Date: 07-Apr-2020
Our Ref: 2020/90441

**Application for Approval of Details Reserved by Condition
Town and Country Planning Act 1990
Planning (Listed Buildings and Conservation Areas) Act 1990**

**Discharge conditions 3, 6, 7, 18 on previous permission 2019/92233 for erection of petrol filling station, including new shop building, canopy, jet-wash and below ground storage tanks
Pennine Service Station, Bradley Road, Bradley, Huddersfield, HD2 1QD
Application Number: 2020/90441**

Workplane (Site) / Perpendicular illuminance (adaptive)**Workplane (Site): Perpendicular illuminance (adaptive) (Surface)****Light scene: Light scene 1**

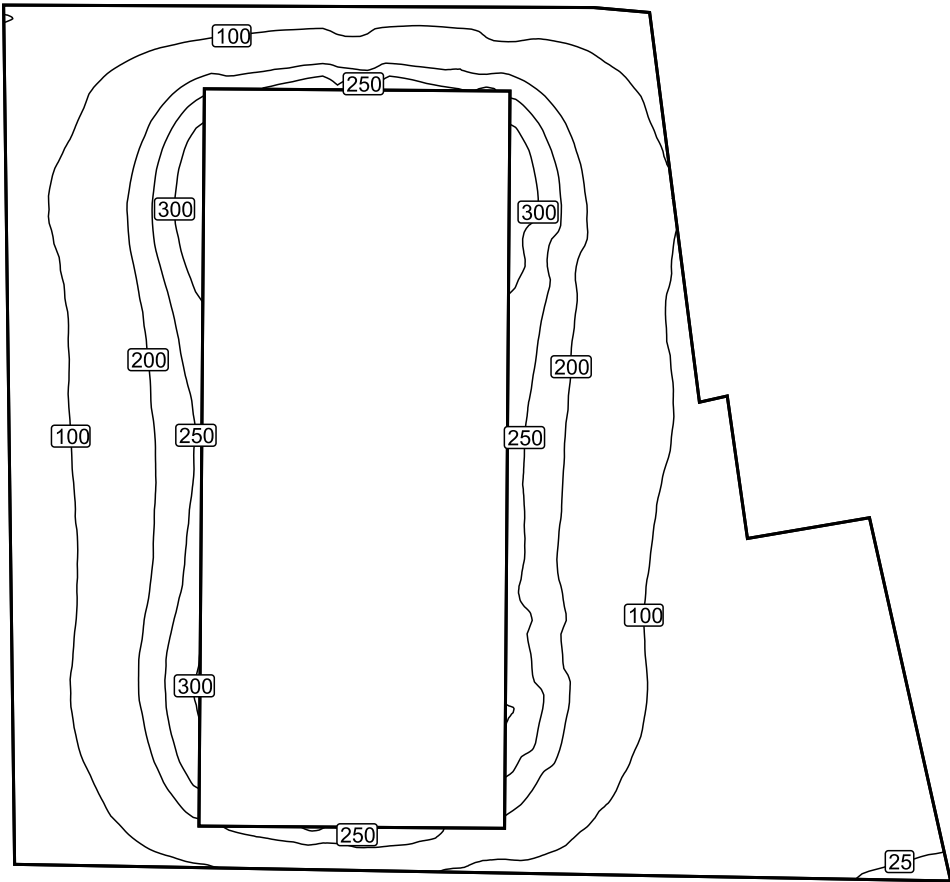
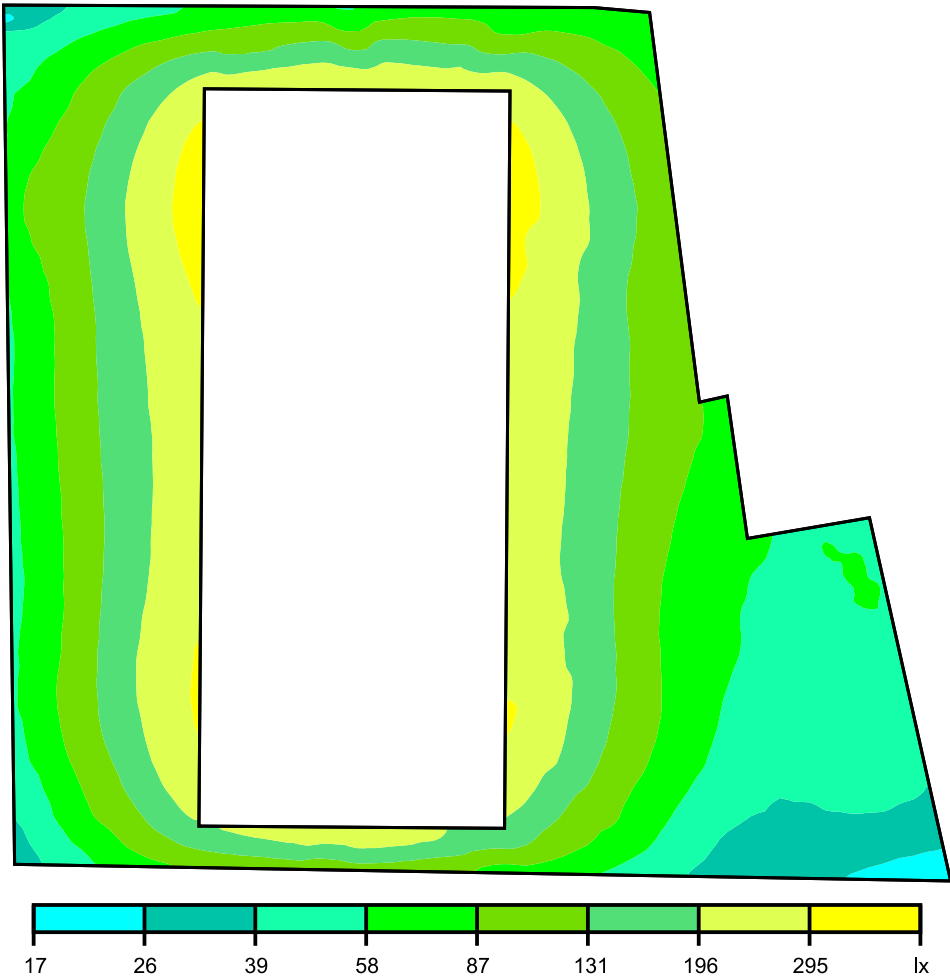
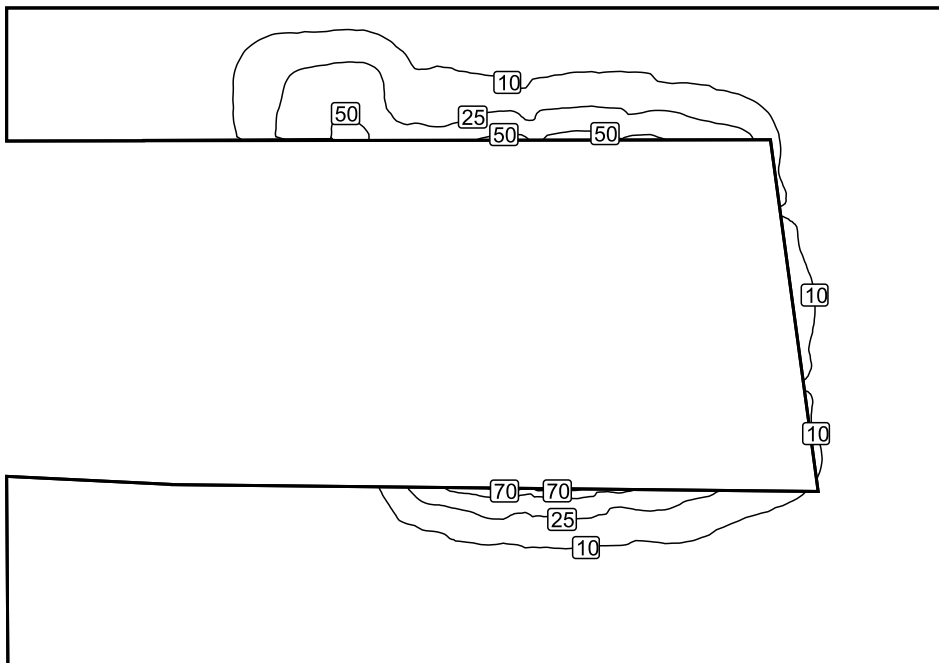
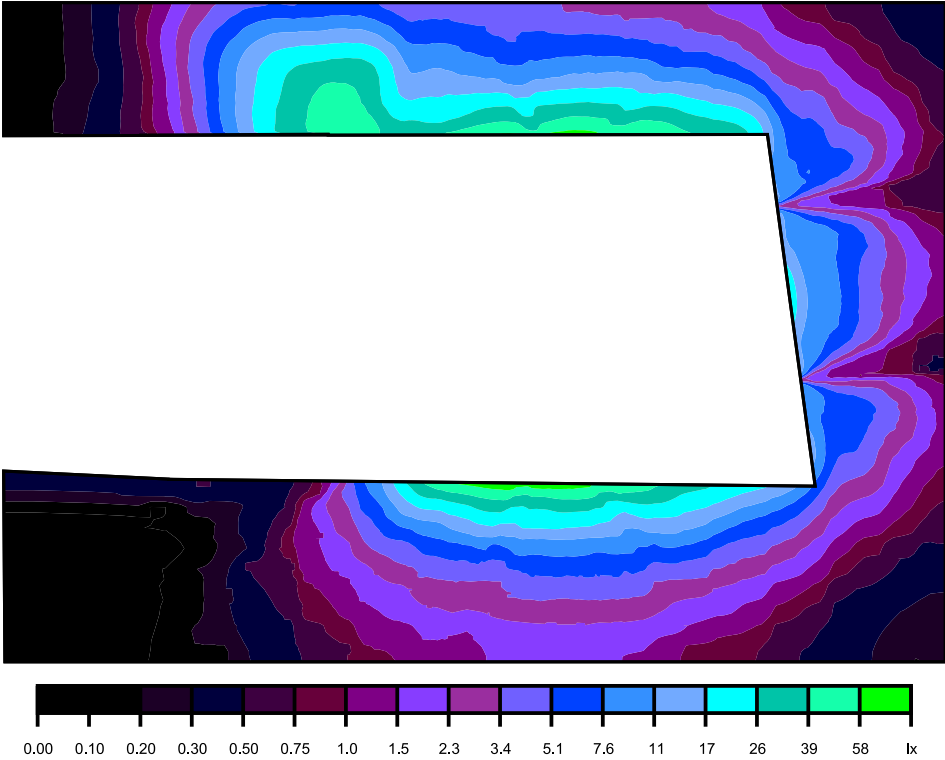
The report refers to perpendicular lighting levels but gives no indication what it is perpendicular to. I also require the horizontal illuminance levels for the site (with some reference to guidance to demonstrate that they are appropriate and not excessive) and the vertical illuminance levels that will be caused at any nearby windows to demonstrate that it's not excessive. The times of operation for the lighting are not apparent in the report either.

DRAWING NO
EWE/2497/01

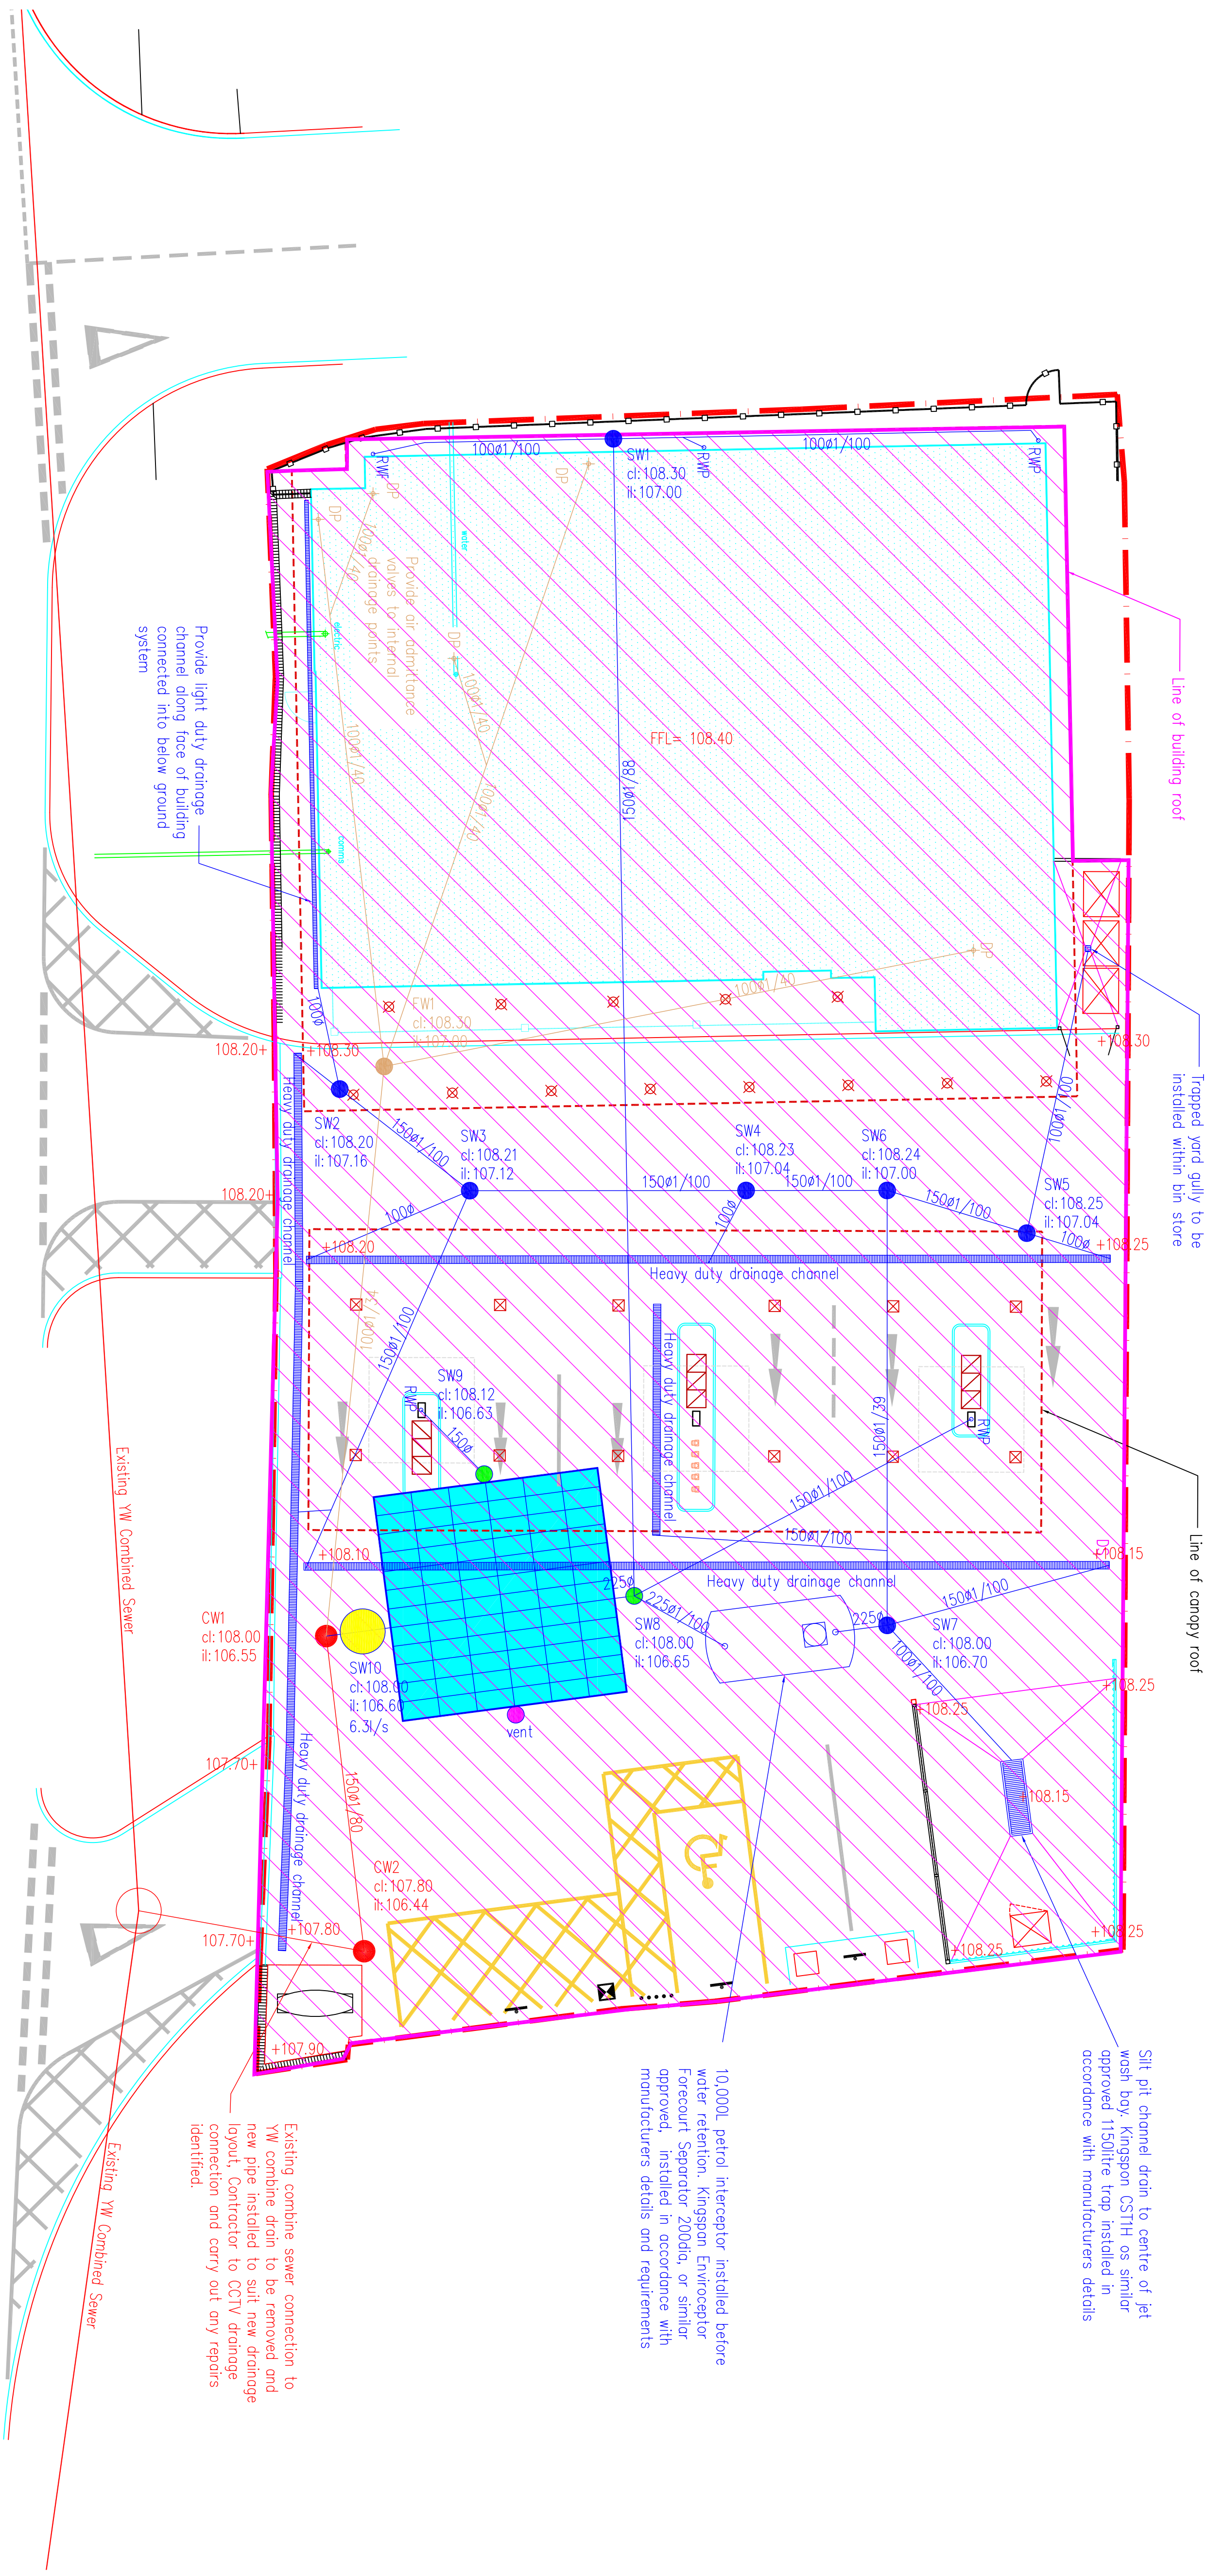
You have submitted the plans ref: 'EWE/2497/01', 'EWE/2497/02' and the Technical Note ref. '001', to discharge conditions 3, 7 and 18. These have been reviewed by the Lead Local Flood Authority, who are unable to support the submitted details.
